Date: 05 March 2019
Our ref: 273538
Your ref: EN010084

Natural England Covering Letter and Hearing Action Points regarding Deadline 3 for the Proposed Thanet Extension Offshore Windfarm

Saltmarsh Mitigation, Reinstatement and Monitoring Plan – Revision B

Figure 2.4
Maximum area of disturbance within the Sandwich Bay to Hacklinge Marshes SSSI.

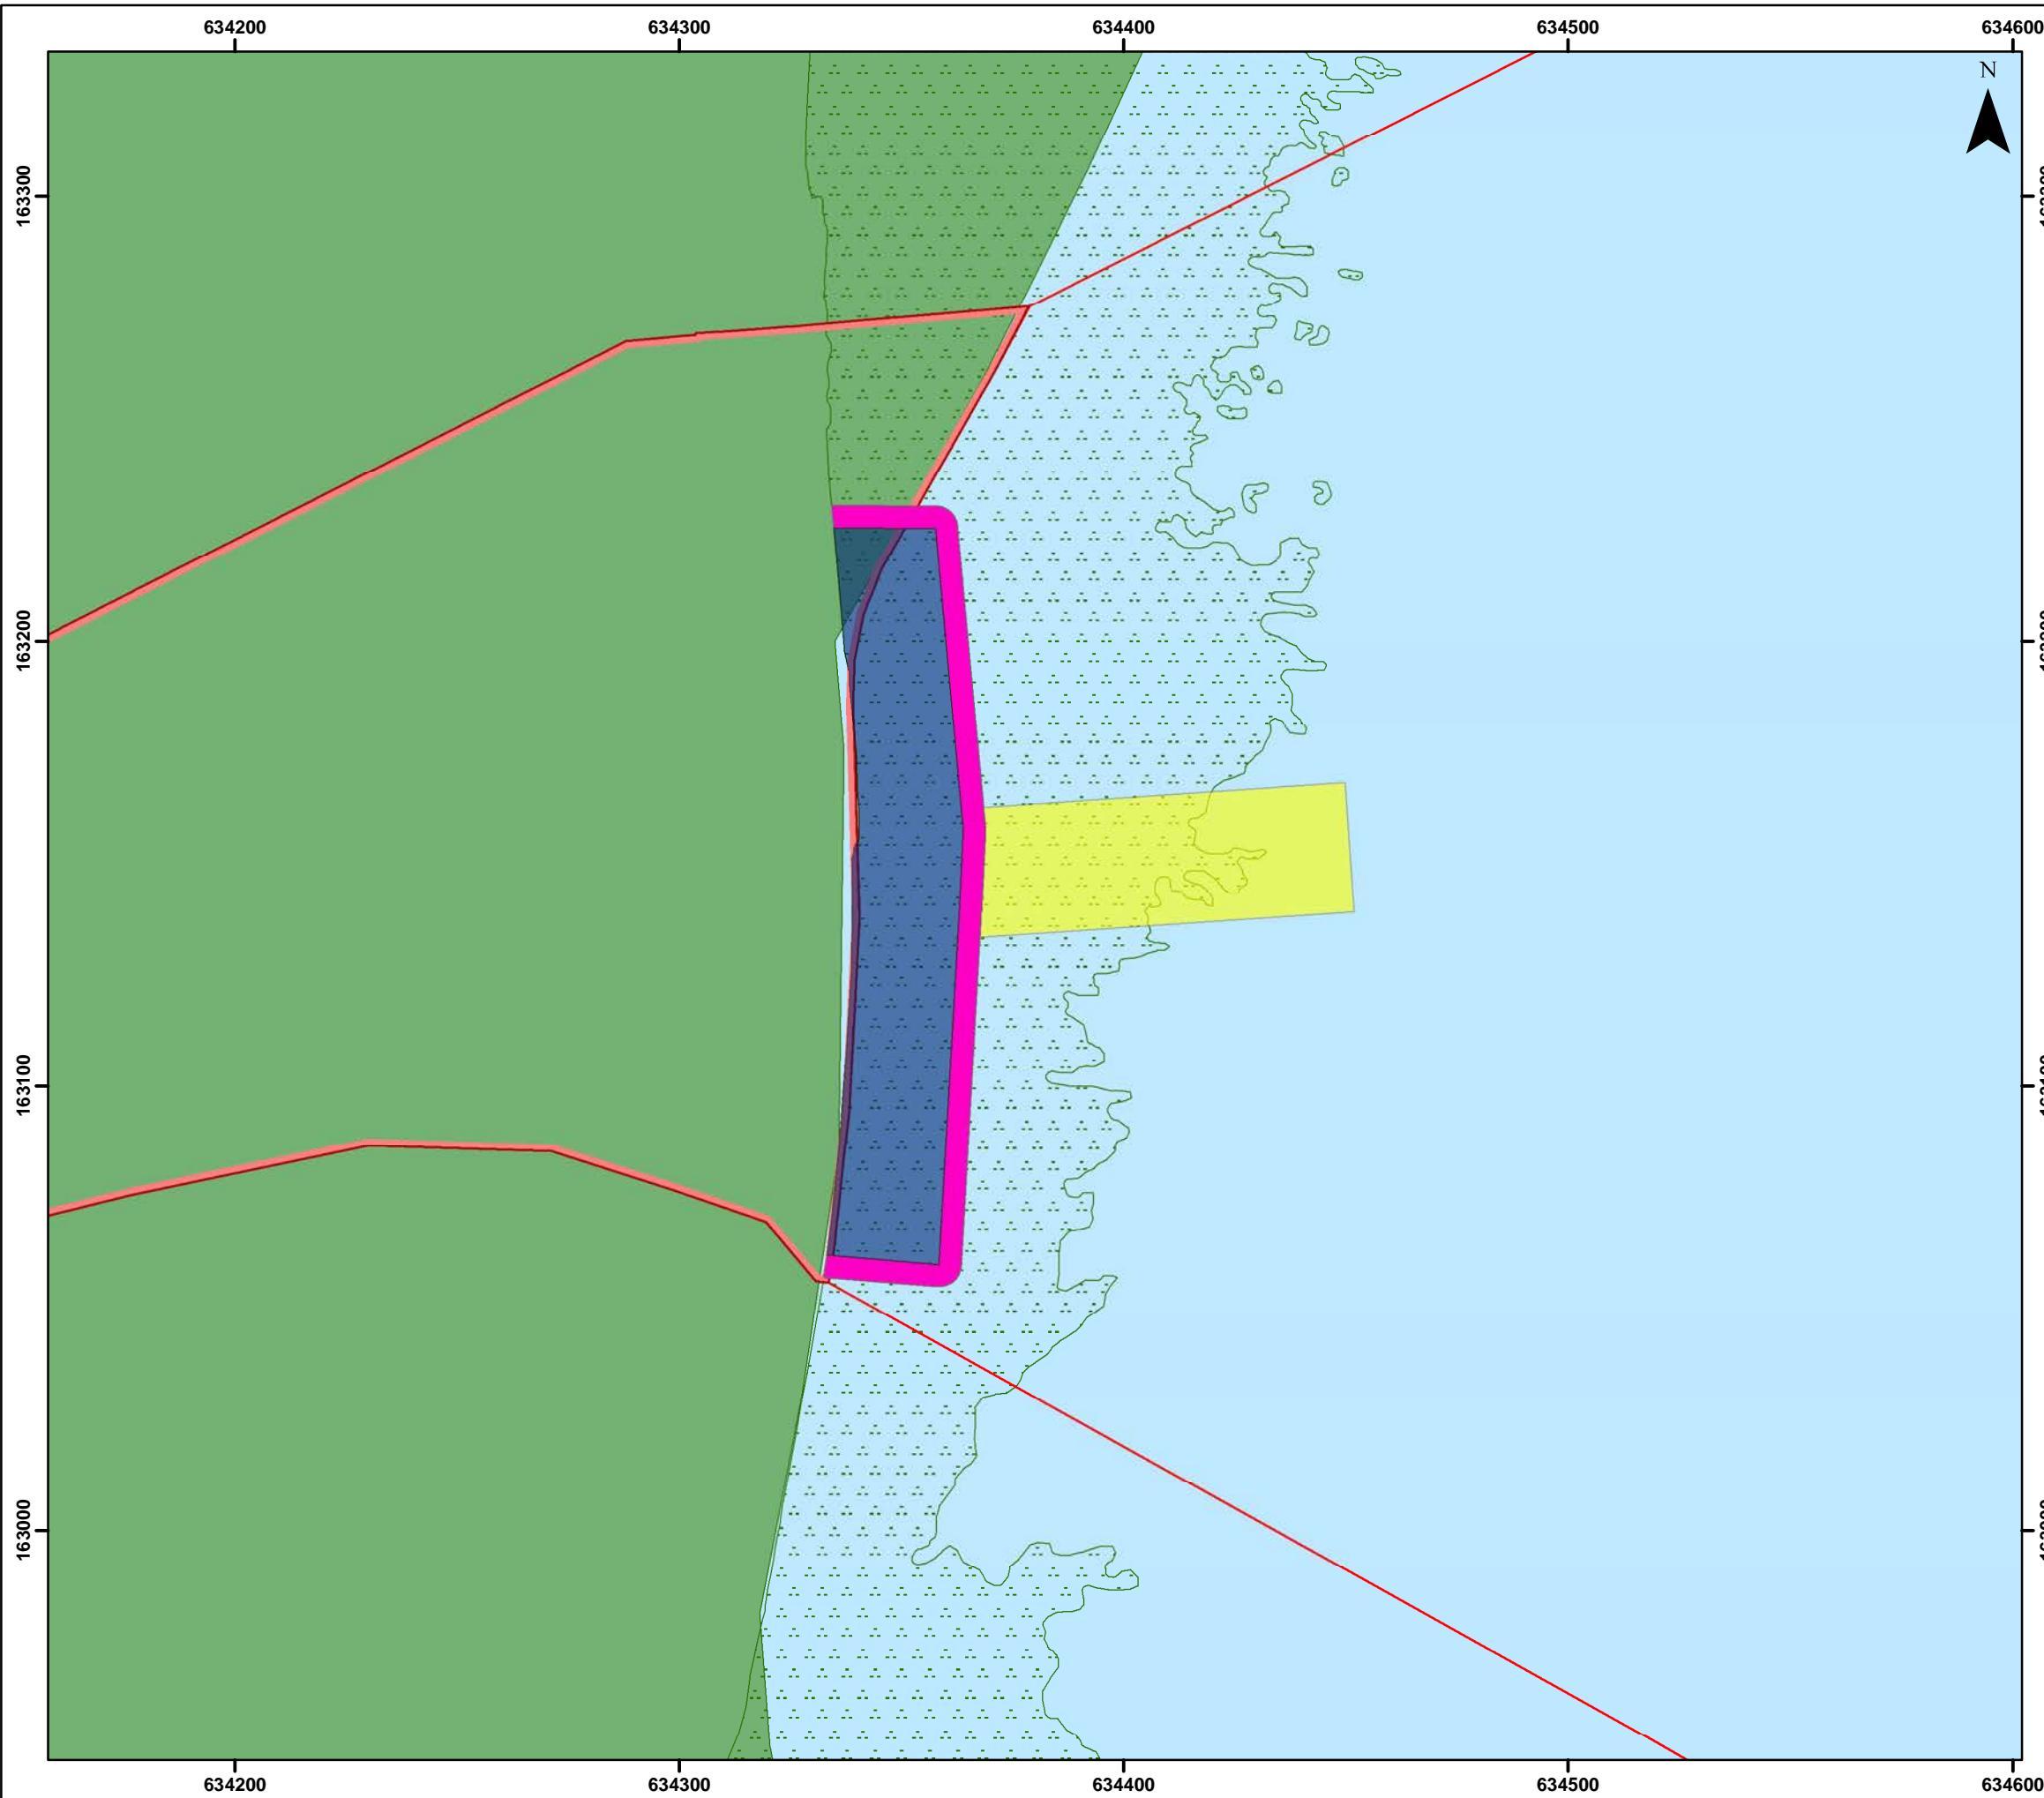
Point Section	Comment
Figure 2-4.	Will the whole 5m separation distance be used by transiting vehicles, and thus be disturbed? Alternatively, will a suitable track be laid within that 5m area?
